PORTLAND MAINE

October 20, 2005

RE: Proposed Grosso Company Self-Storage Building
980 Riverside Street
Application ID#2005-0200

THE GROSSO COMPANY
PROPOSED STORAGE
BUILDING
980 RIVERSIDE STREET
PORTLAND, ME 04103

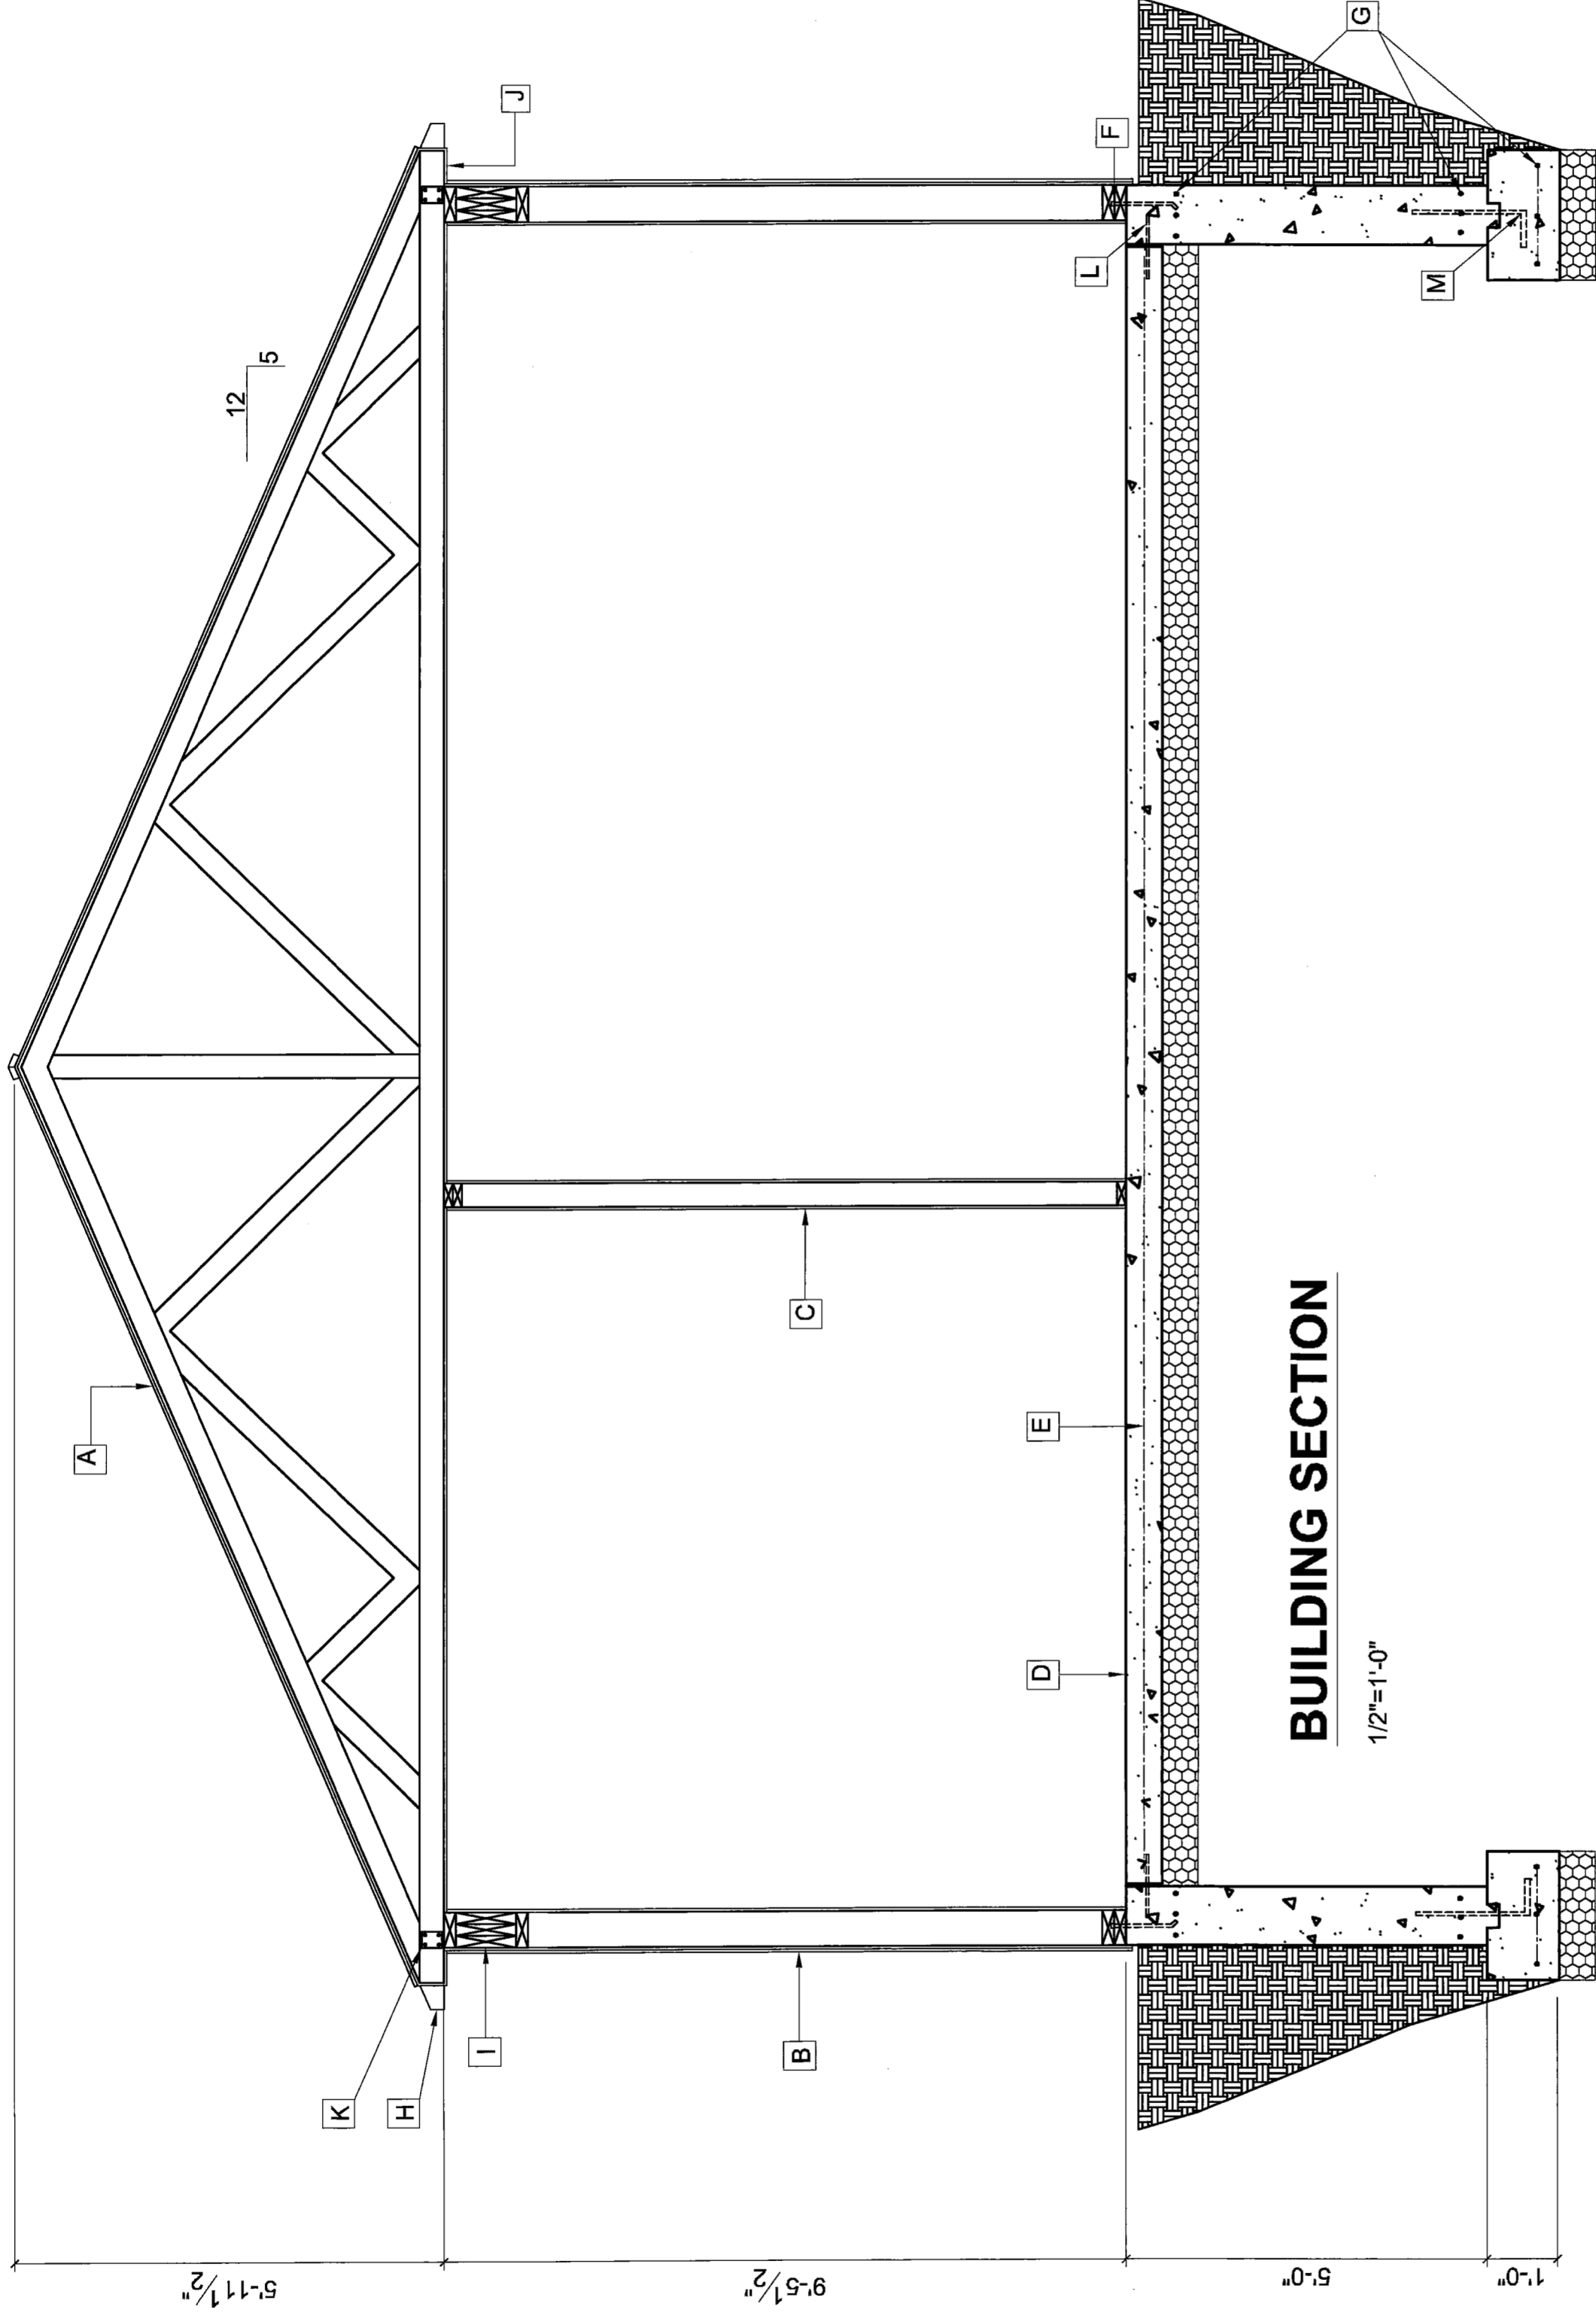
1. The proposed project requires 15 parking spaces yet only 10 are provided on the site plan.
2. Documentation must be proved to support the presented imperious surface calculation.

** When entering the site on the easterly driveway, a severe bump exists. I would suggest that the bump be mitigated.*

** I would suggest that the proposed 20' gravel drive be regulated to one-way flow. Appropriate signage should be provided. The drive should be widened to 24' if two-way flow is desired.*

** At the time of my field investigation several vehicles were parked to the rear of the existing office building. The six parking spaces do not appear adequate to meeting parking demand. An explanation should be provided.*

Planning staff strongly encourages the applicant to close one of the two existing curb cuts to Riverside Street or provide a narrative justifying the continuation of existing conditions.

The proposed parking analysis identifies a requirement for 15 on-site parking spaces, nevertheless, only +/- 10 spaces are shown on the proposed site plan. Please revise the site plan to show 15 on-site parking spaces. Those spaces should be dimensioned on the plan. Handicap space(s) should also be identified on the plan in conformance with State and Federal requirements.

A complete stormwater management plan must be prepared and submitted in order for compliance with this section to be determined. The plan should include:

- Proposed grading and drainage
- Stormwater calculations for 2, 10, and 25 year storm events
- Engineering plans including pipe sizes, inverts, basins, etc.
- Stormwater treatment performance
- Submittal of drainage easements or legal rights for discharging to abutting properties.
- Submittal of a formal erosion control plan

There appear to be areas of significant existing vegetation to the rear of the site. Areas of significant tree cover should be called out on the plan. Tree save areas should be identified where practicable.

Based on the information submitted to date, the proposed lighting plan appears to conform with this section, however, please indicate the light source type proposed within the fixture (e.g. sodium, halide, etc.).

The City's Fire Prevention Officer has reviewed the proposed plans and requests that the nearest hydrant be shown on the plan. Fire code will require that a hydrant exist within 500 feet path of travel from any structure on site.

Please provide landscaping so as to screen and enhance the site in conformance with this section. As per this section, particular attention should be paid to parking and front yard setback areas.
